Application for a Non-Material Amendment Following a Grant of Planning Permission

Coniston Gardens

Erection of a part single storey, part two storey side extension, and a single storey rear extension

18293/APP/2025/1184

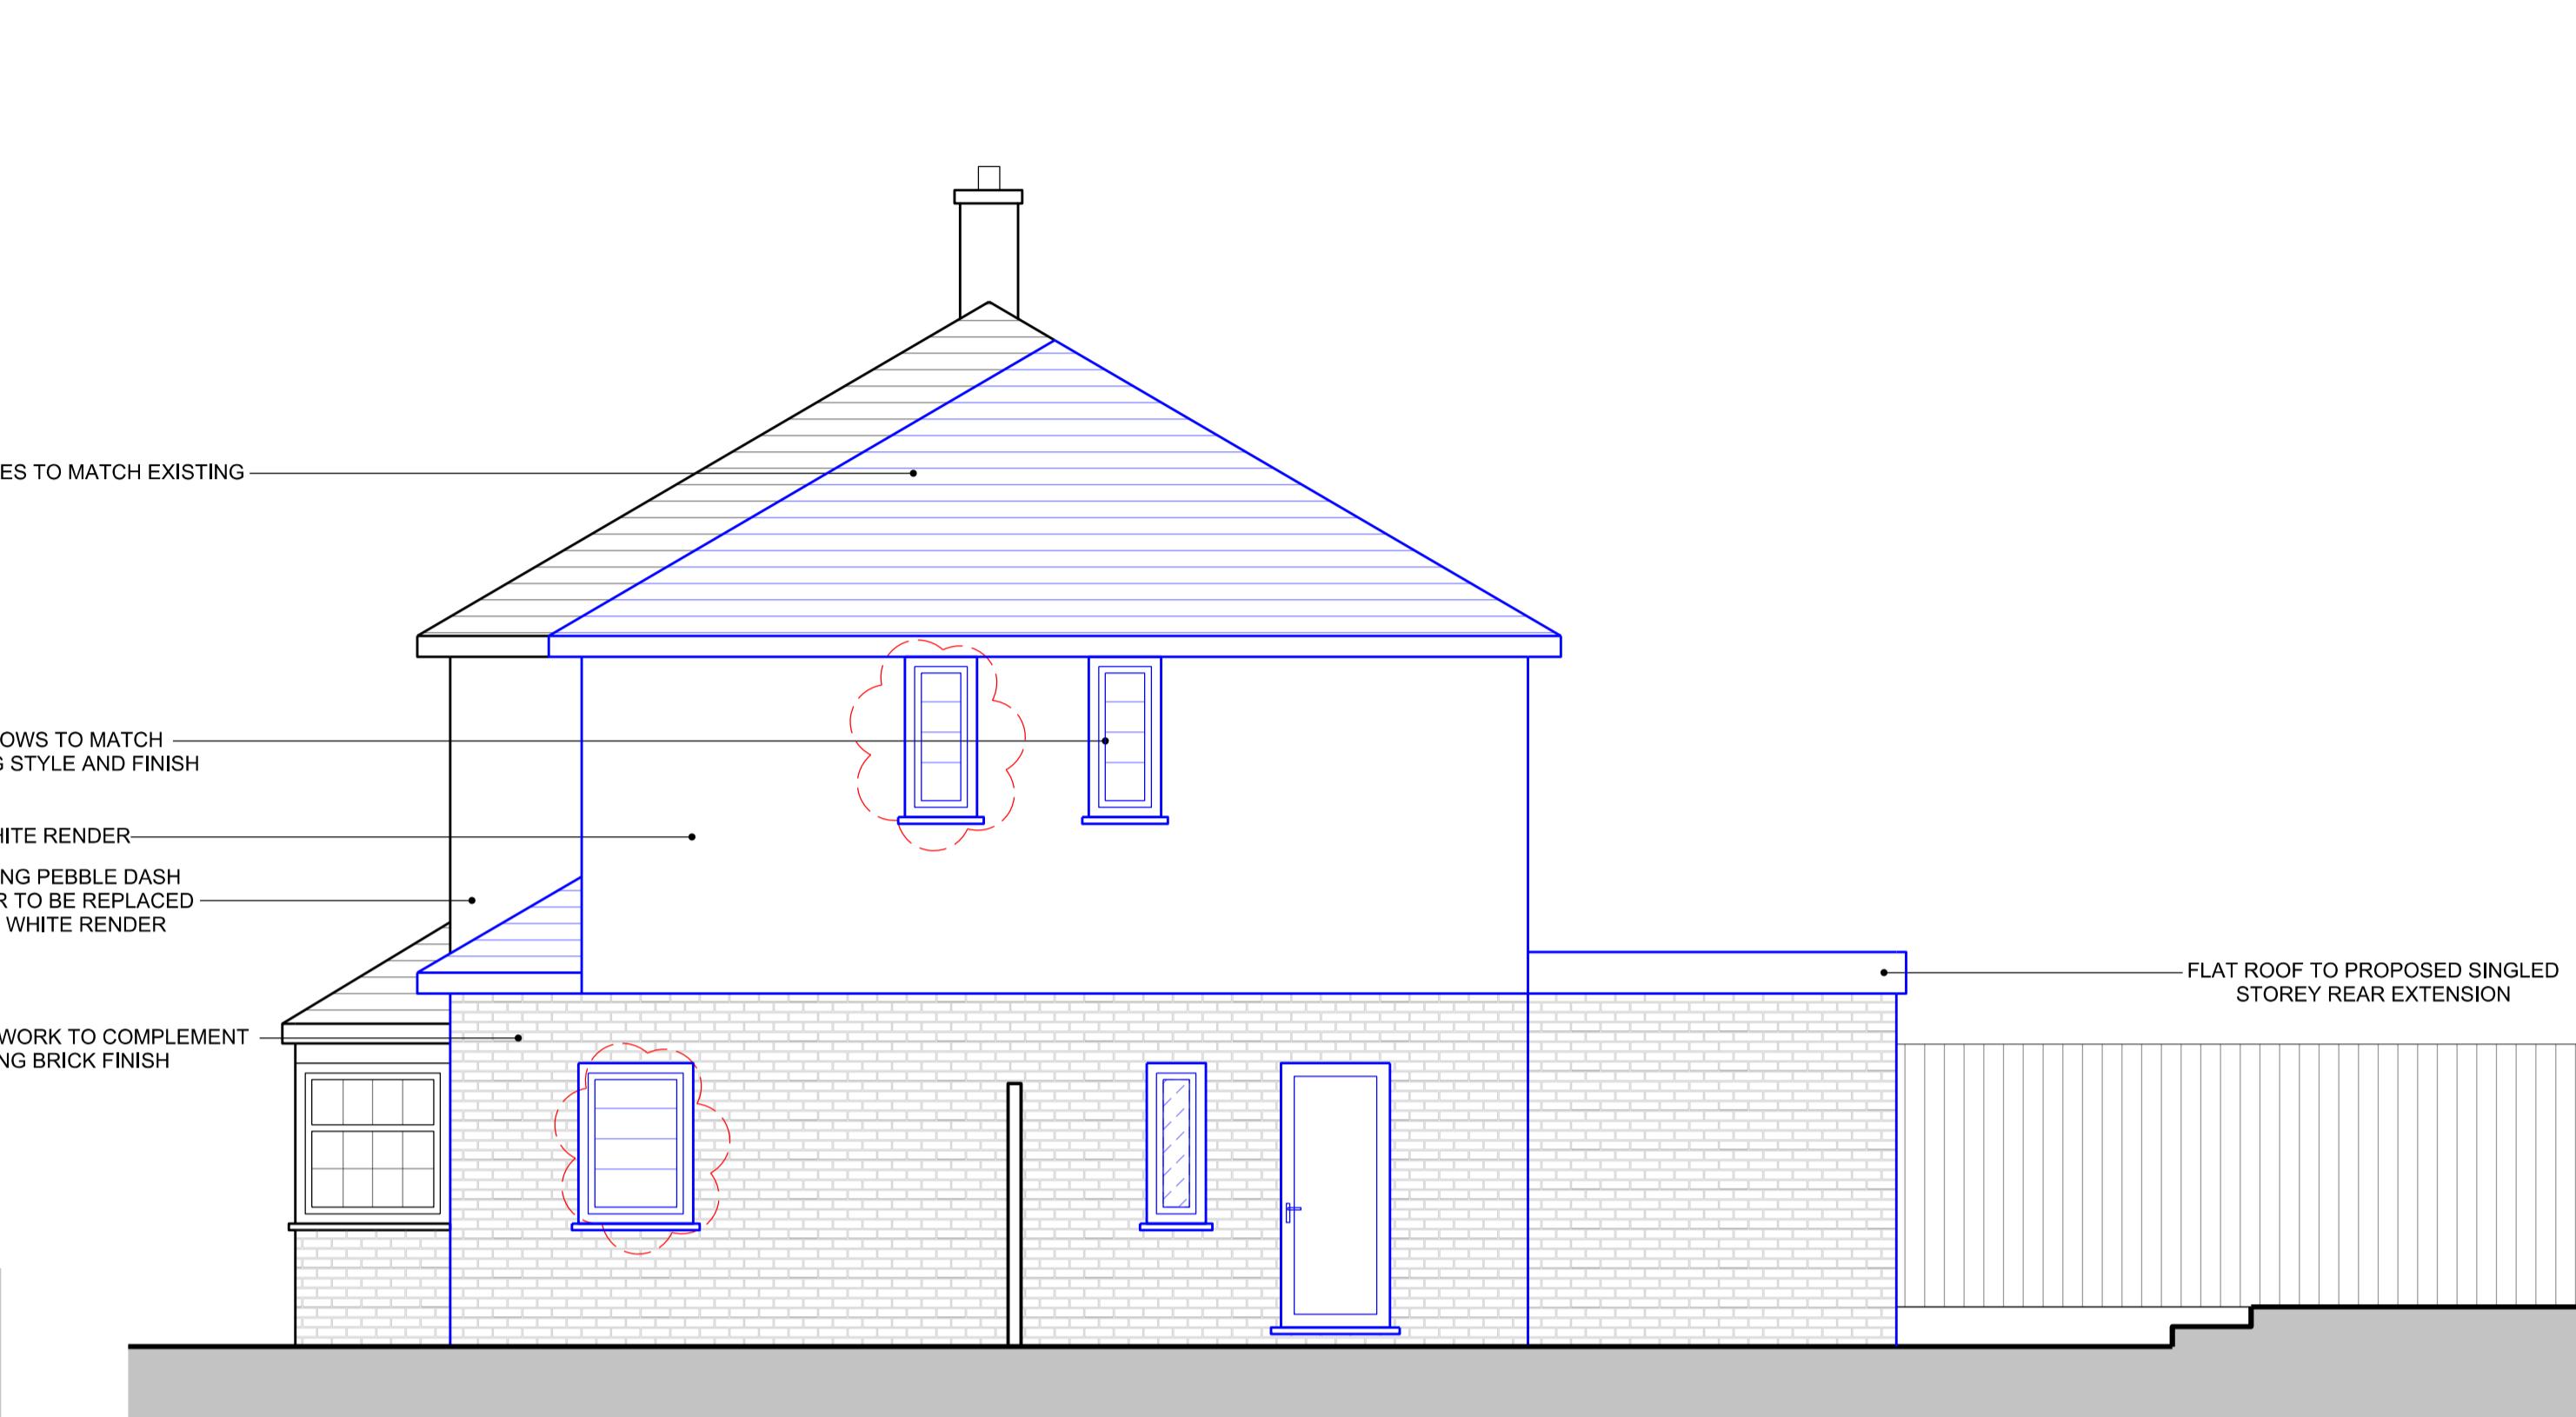
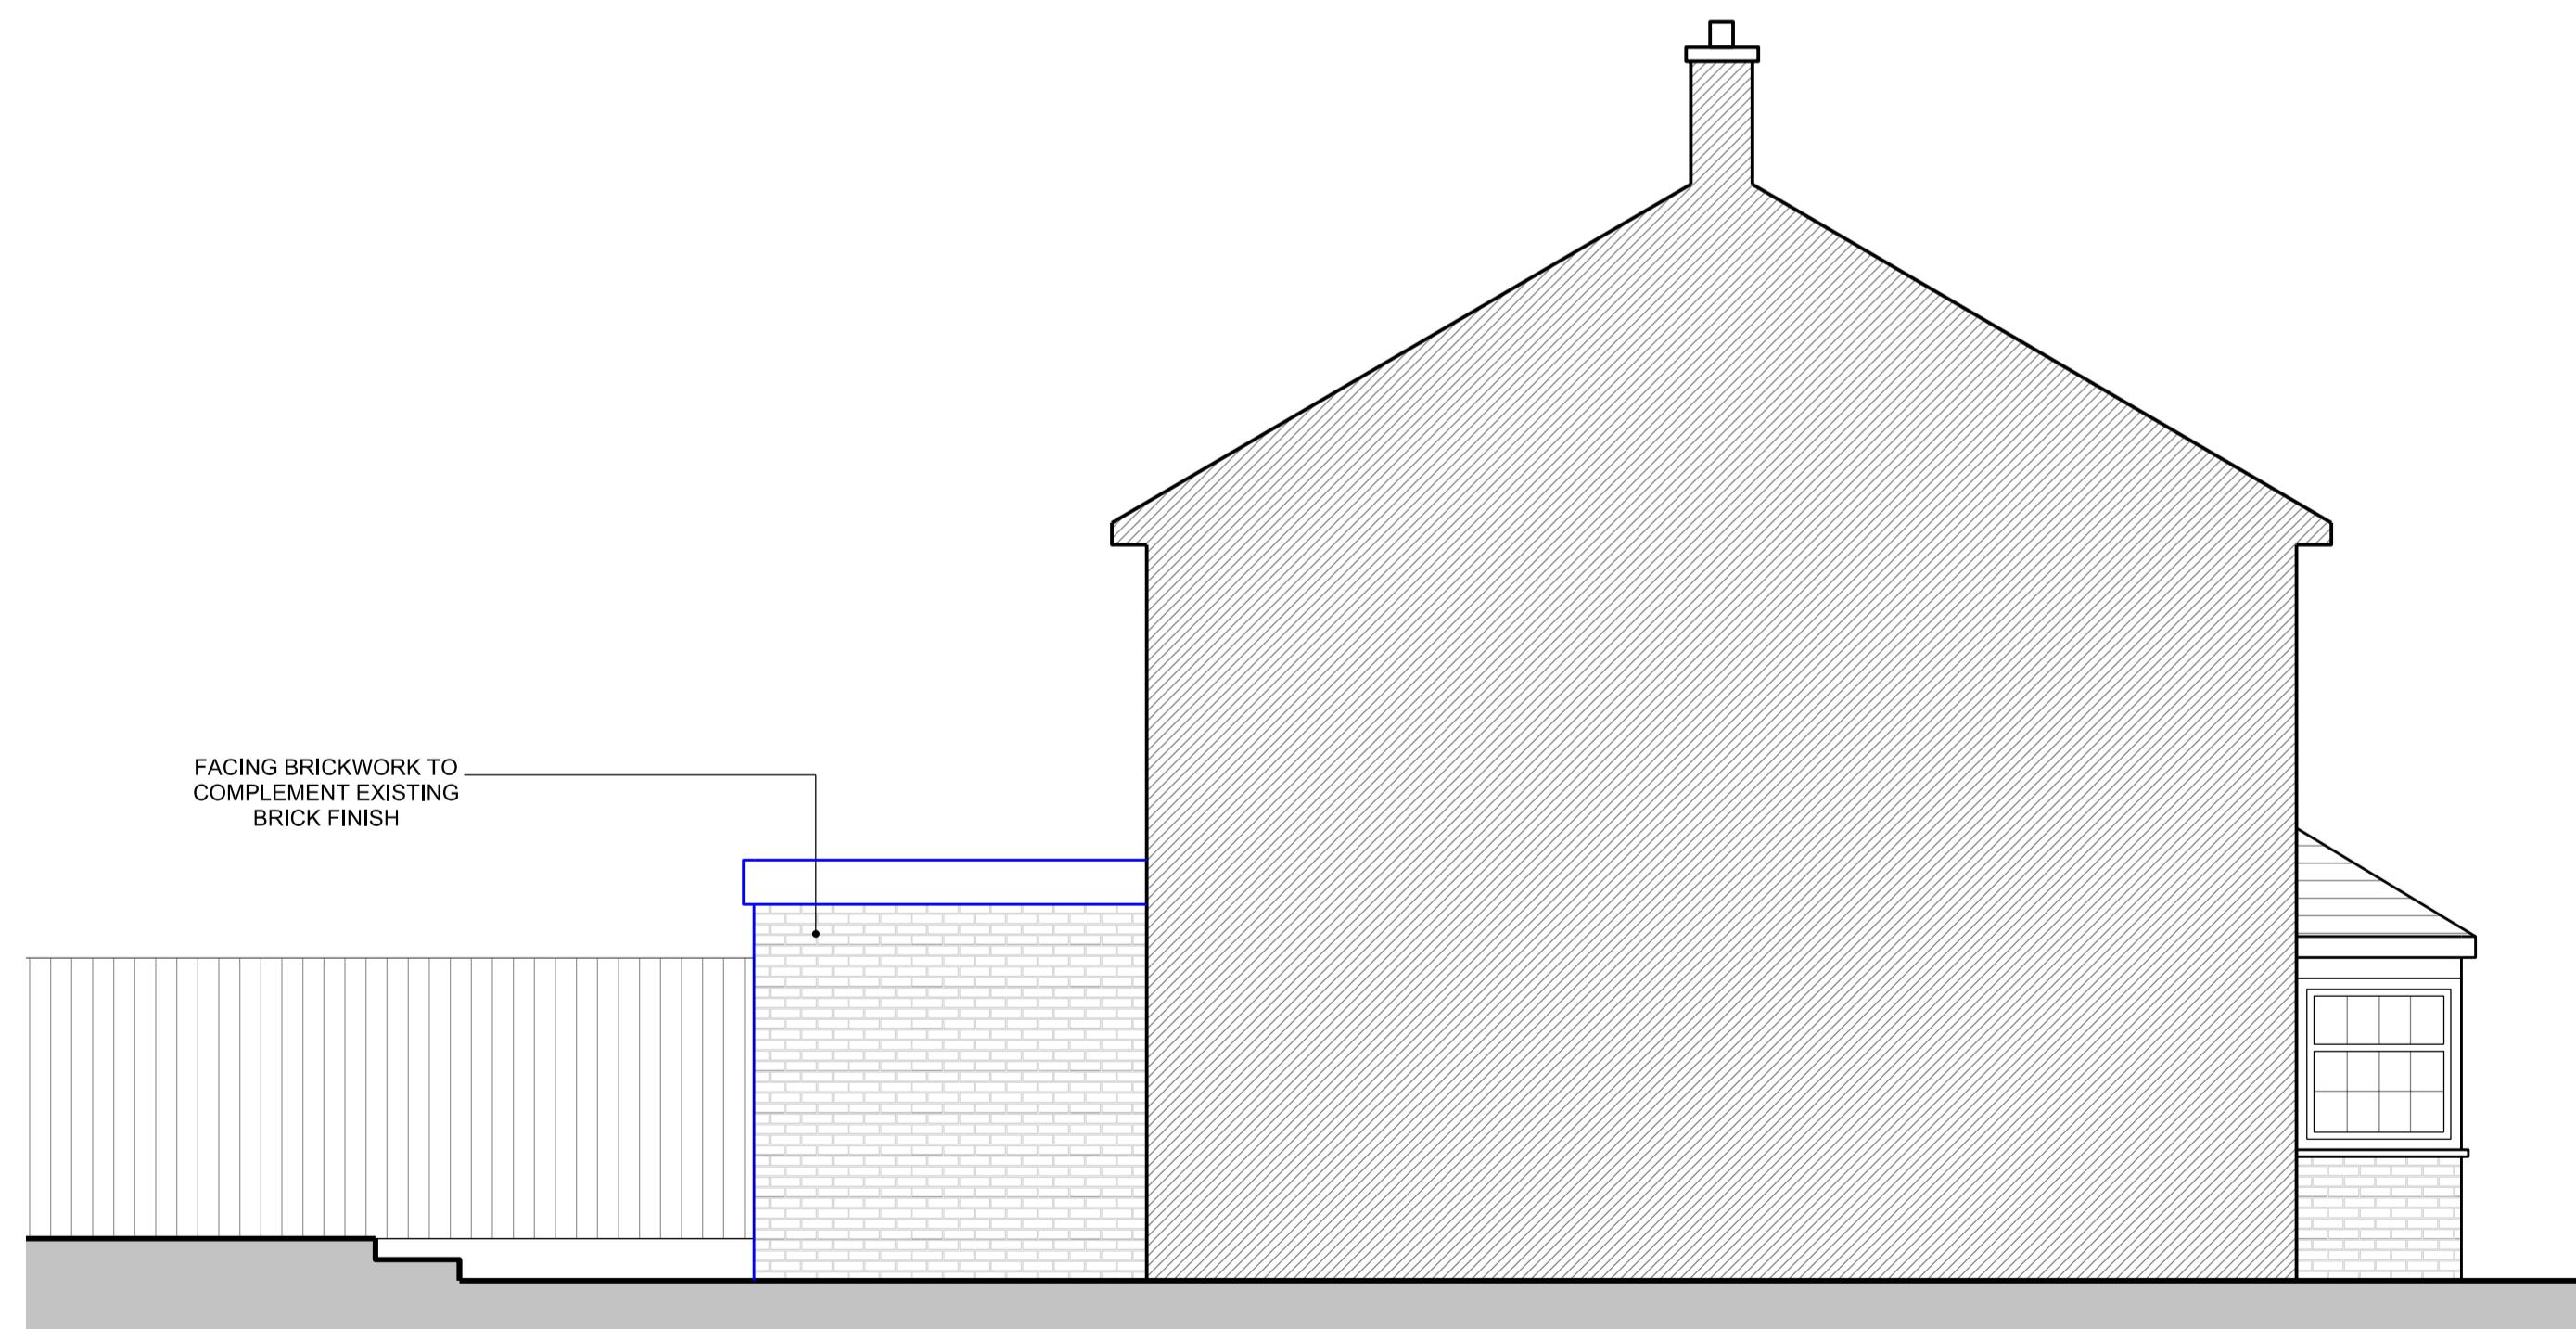
Increased width to approved ground floor bifold door to rear elevation
Increased width to approved ground floor window to side elevation
Proposed new single window to first floor side elevation
Proposed 2no. roof lights to ground floor single storey rear extension. Roof lights to protrude maximum 150mm from roof plane

To help increase daylight entering internal space and provide flexibility in internal furniture arrangement
